From: Martyn White
Sent: 26 January 2015 15:16
To: David Easton
Subject: AW/335/14/HH

**ADC Planning Consultation
Response from the Conservation Officer**

Application Number	AW/335/14/HH
Address	4 Tithe Barn Way Aldwick PO21 4HA
Description	Alterations, garage extension & new garden walls
Case Officer	Mr. D Easton

Title
Ground Floor
Plans as Proposed

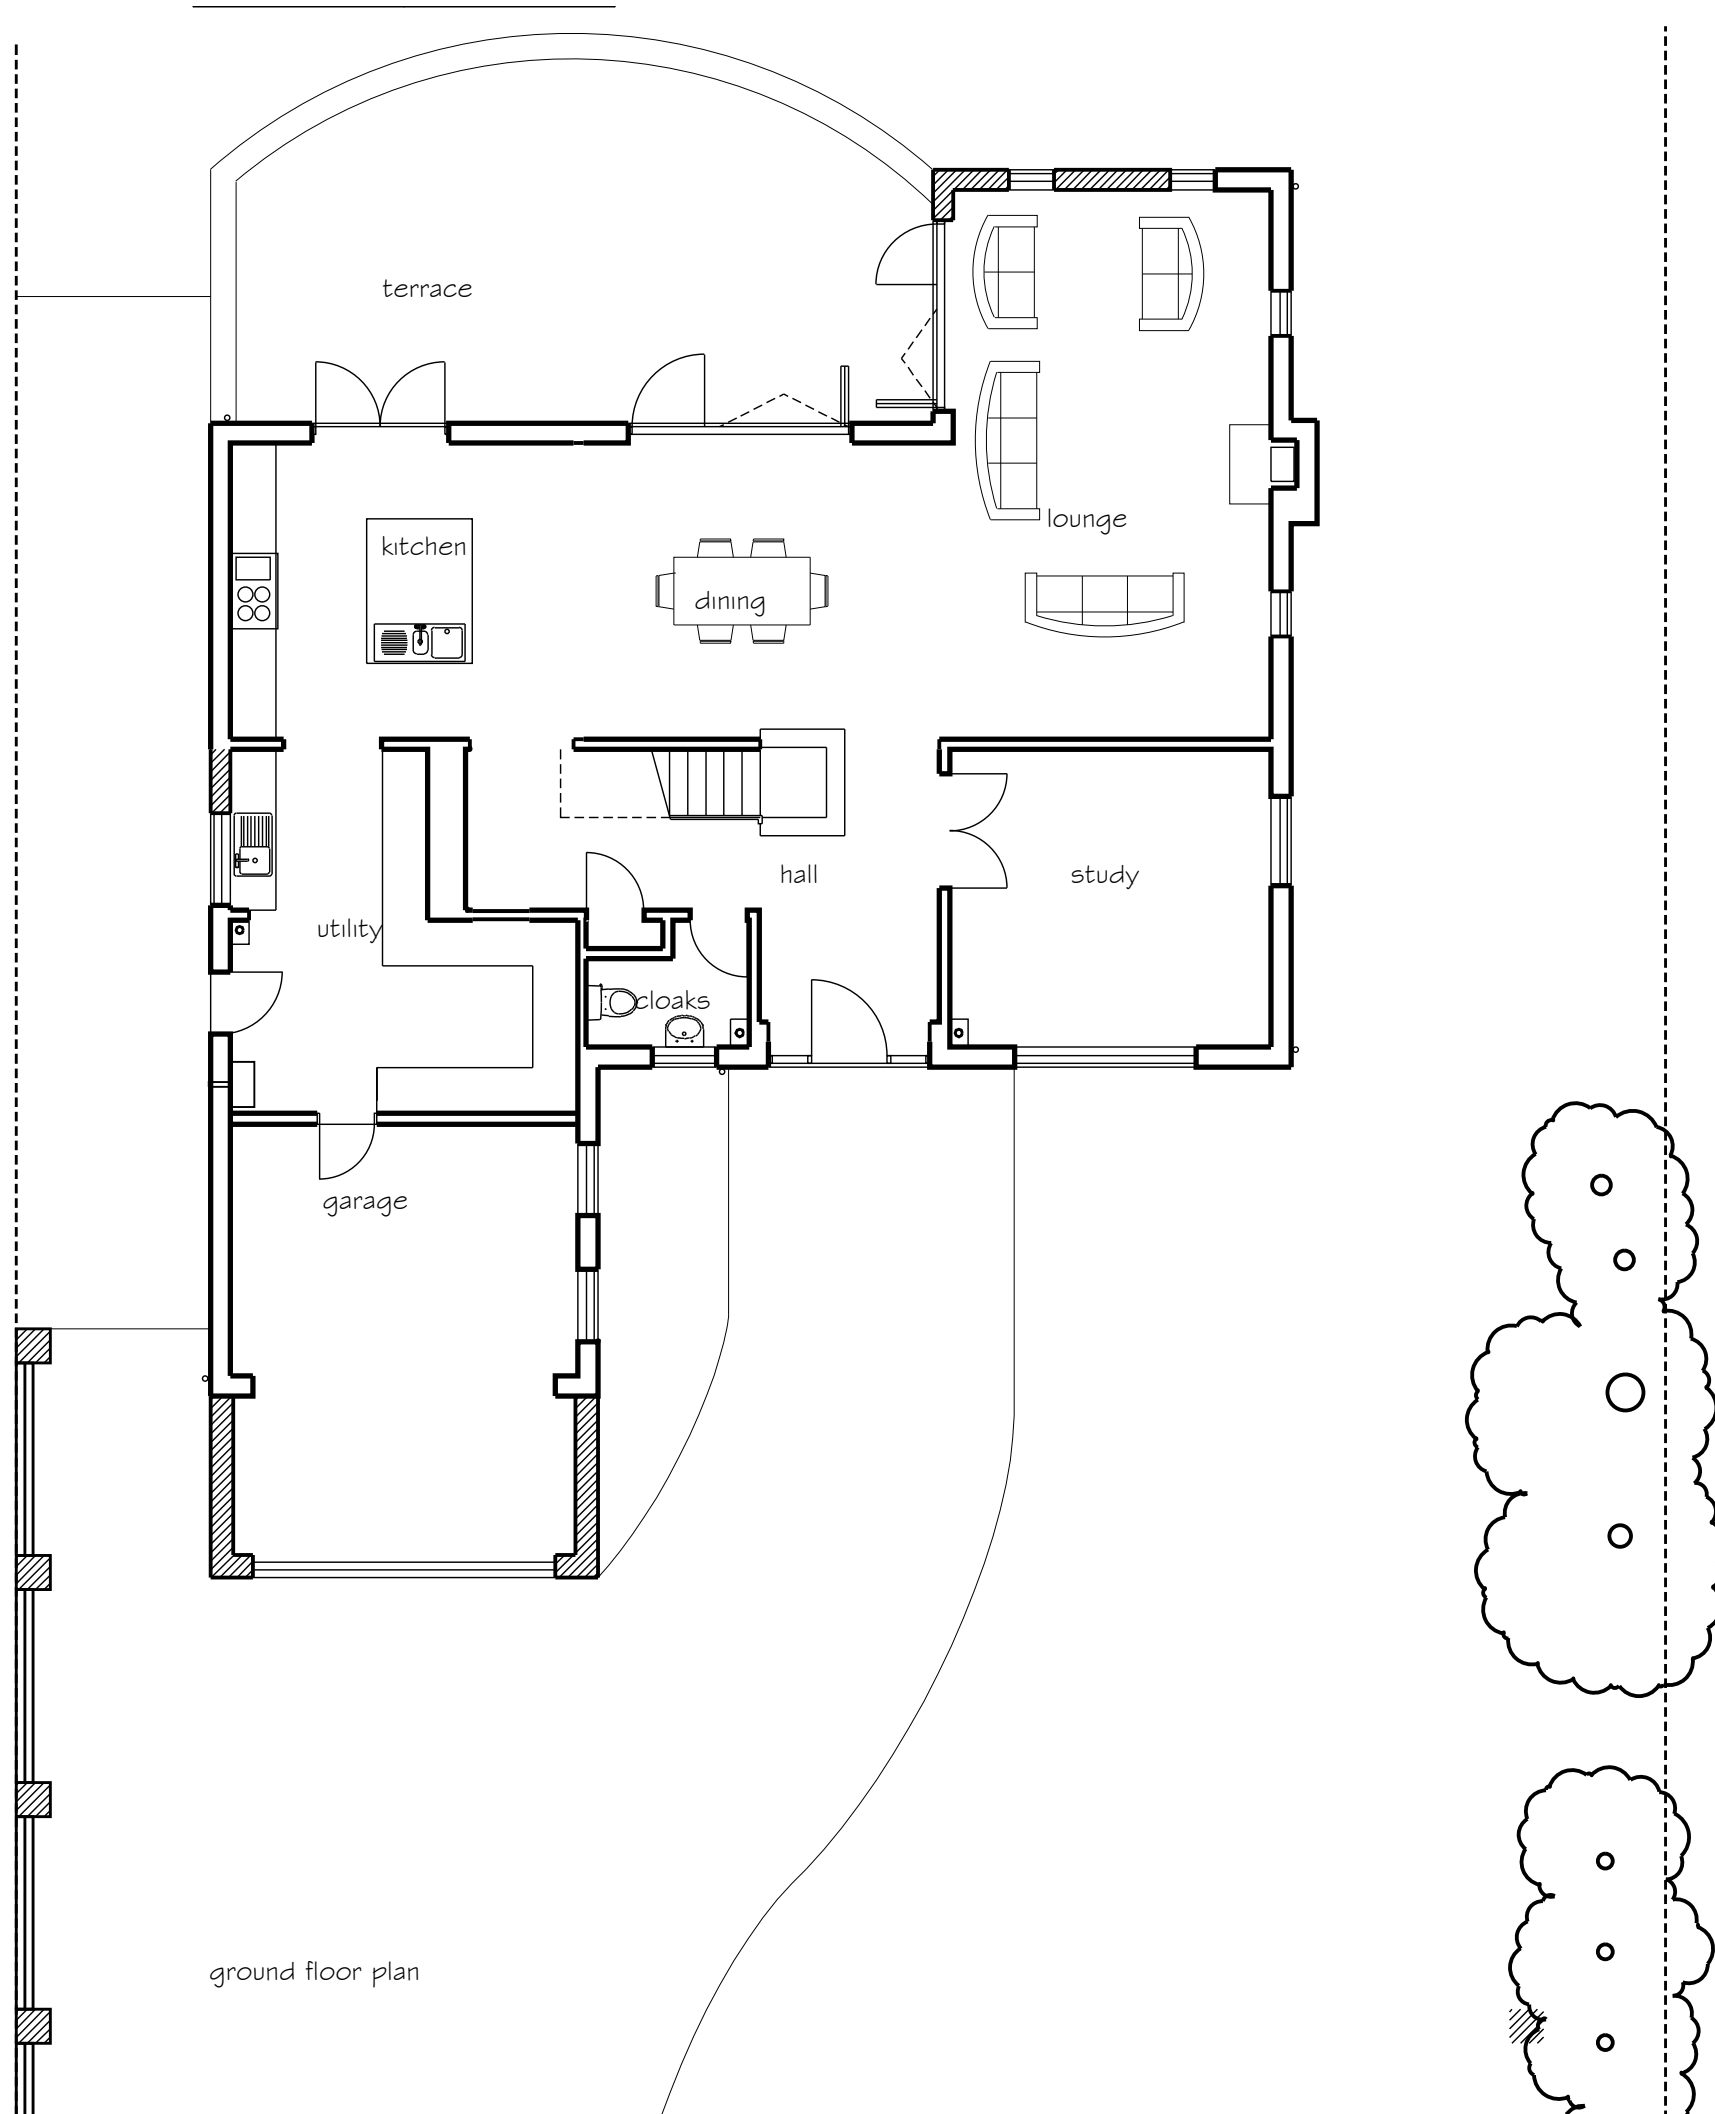
It is considered that the alterations to the property will result in a neutral impact. However, there is some concern with the proposed front boundary wall. It will appear to be higher than those in the surround/neighbouring properties. It will also be treated in a different material (render). It has the potential to have a greater impact upon the street-scene than those that surround it.

If minded to approve, details of the colour of the render should be provided.
